City of Portland, Maine - Building or Use Permit Application
 389 Congress Street, 04101 Tel: (207) 874-8703, Fax: (207) 874-8716

Permit No: 09-1248	Issue Date:	CBL: 155 E007001
------------------------------	--------------------	----------------------------

Past Use: Vacant / Demolition of House (permit #09-1028)	Proposed Use: Build new 1,911 square foot single family home with 475 square foot attached garage.	Permit Fee: \$1,585.00	Cost of Work: \$149,000.00	CEO District: 4
		FIRE DEPT: <input type="checkbox"/> Approved <input type="checkbox"/> Denied		INSPECTION: Use Group: Type
Proposed Project Description: Build new 1,911 square foot single family home with 475 square foot attached garage.		Signature:		Signature:
		PEDESTRIAN ACTIVITIES DISTRICT (P.A.D.) Action <input type="checkbox"/> Approved <input type="checkbox"/> Approved w/Condition <input type="checkbox"/> Denied Signature: Date:

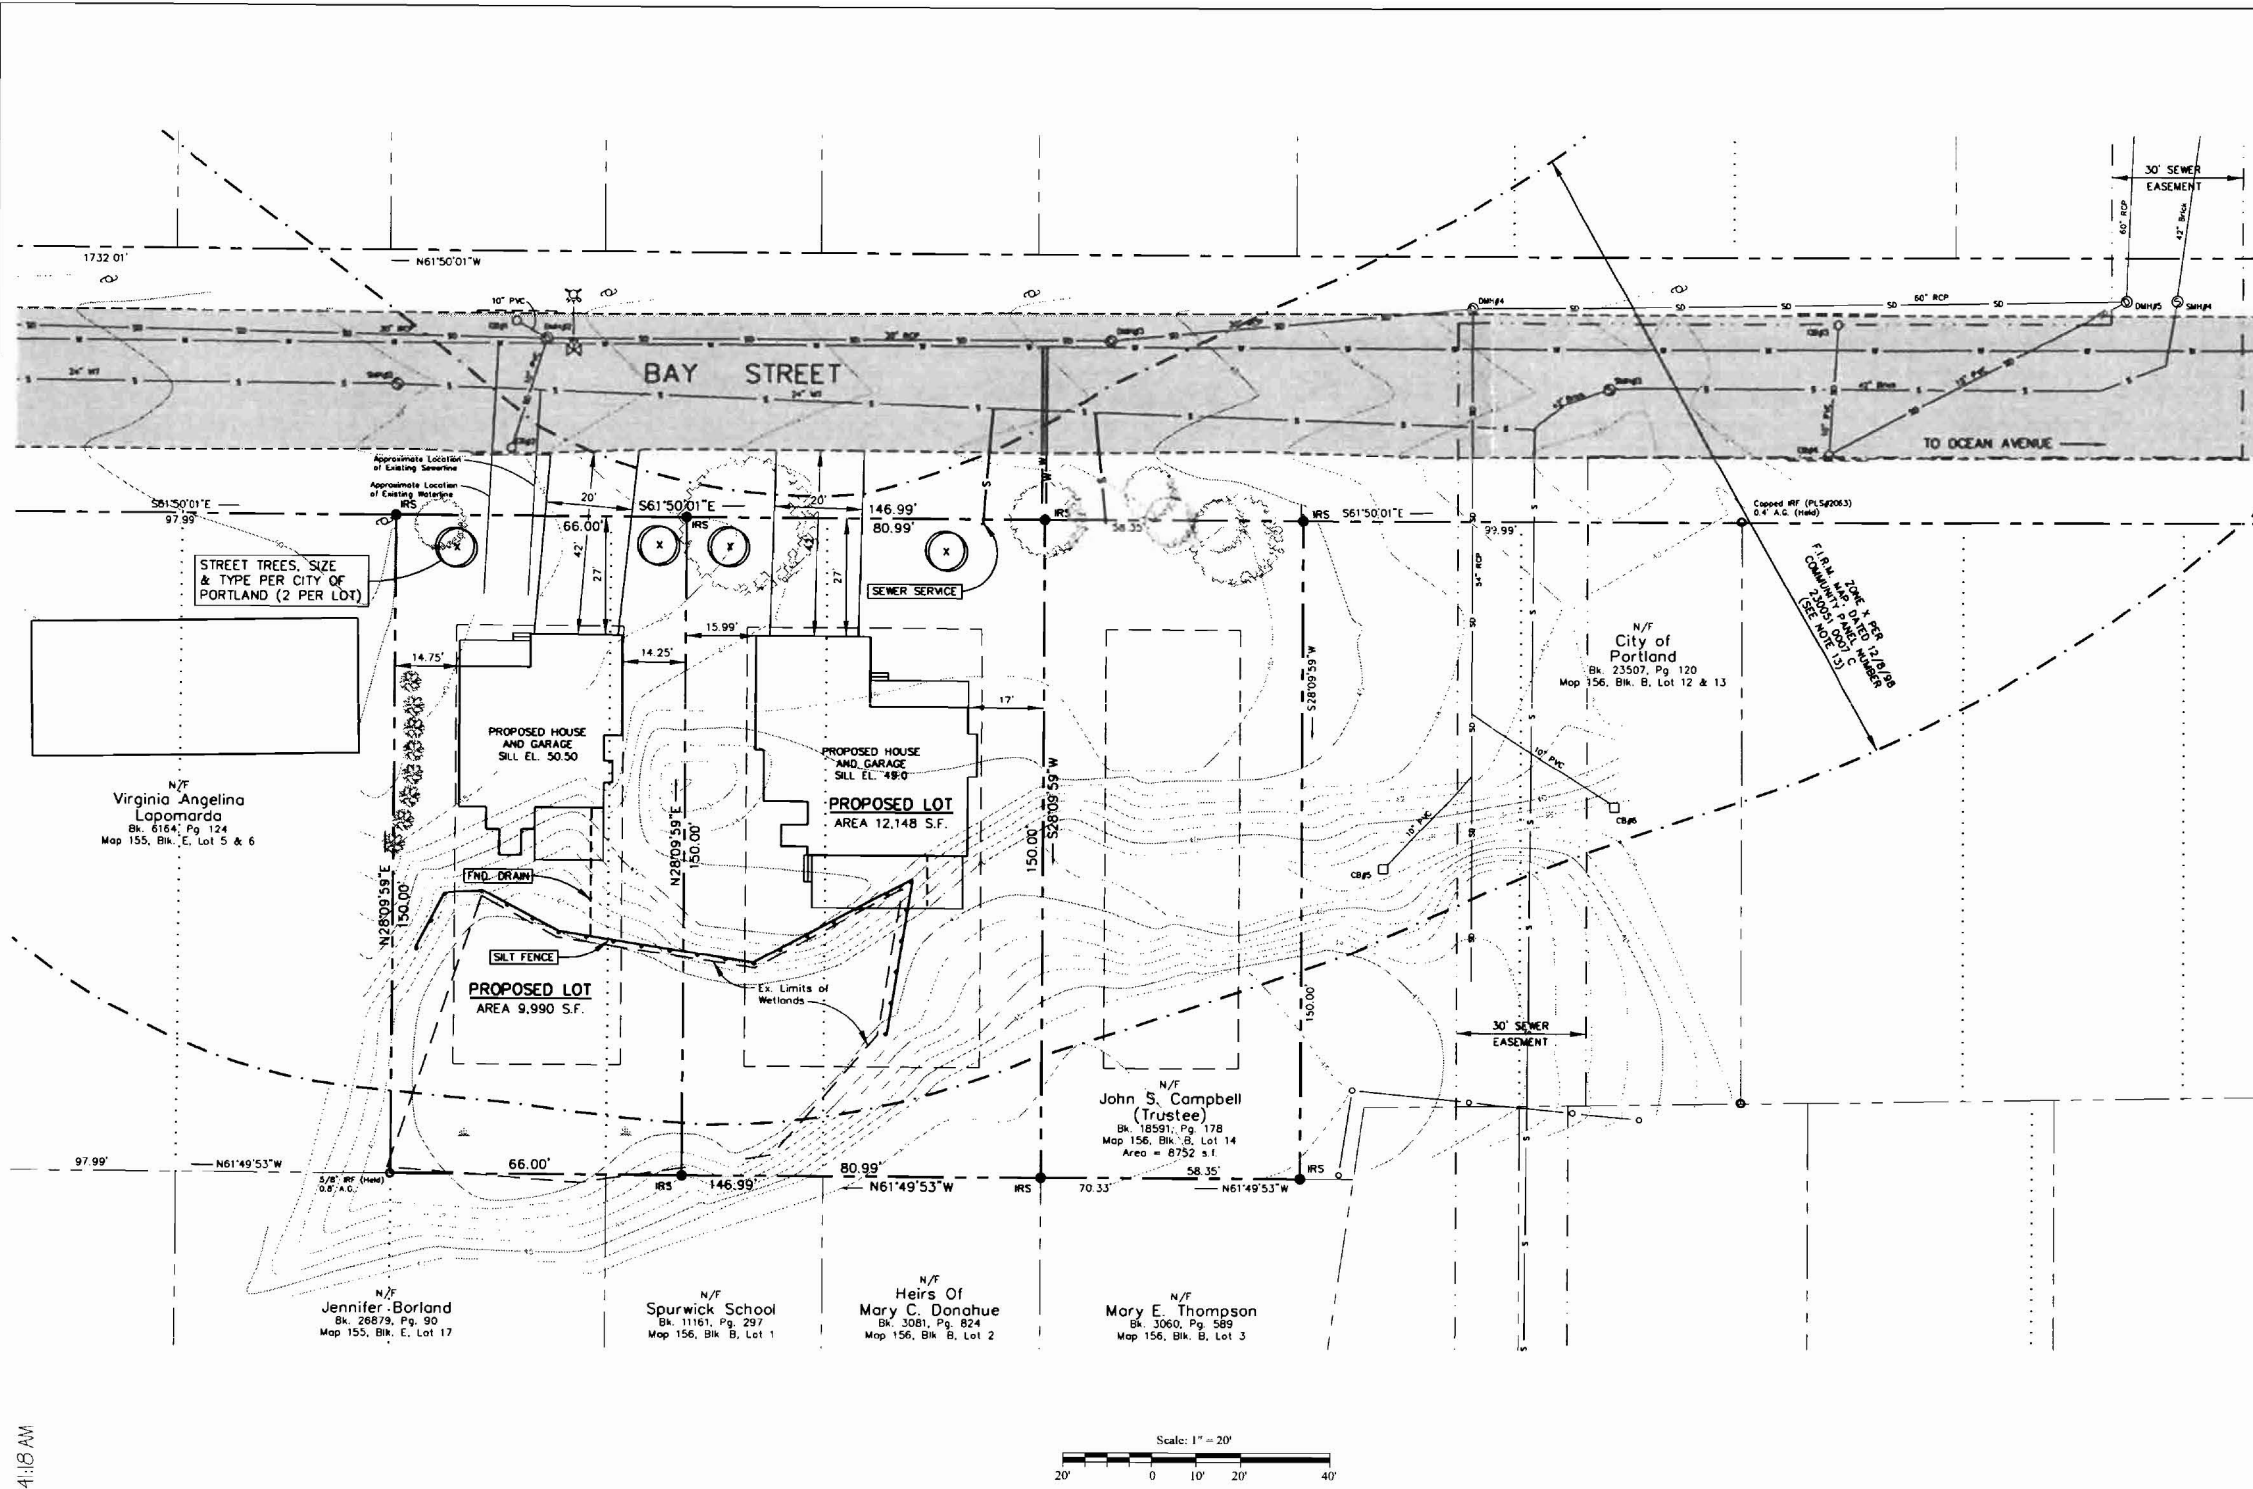
11/10/2009-amachado: Done intial review. Siteplan does not show the rear deck & stairs, front porch & stairs , and the "chimney" bumpout. I have emailed Phil. I need these added to the siteplan. I'm moving the permit forward to a plan reviewer, but I can't sign off yet. Called Mike Wilson.

12/12/2009-amachado: Received revised siteplan.

12/10/2009-amachado: Planning received revised site plan. Reviewed it. No changes to zoning; grading changes only.
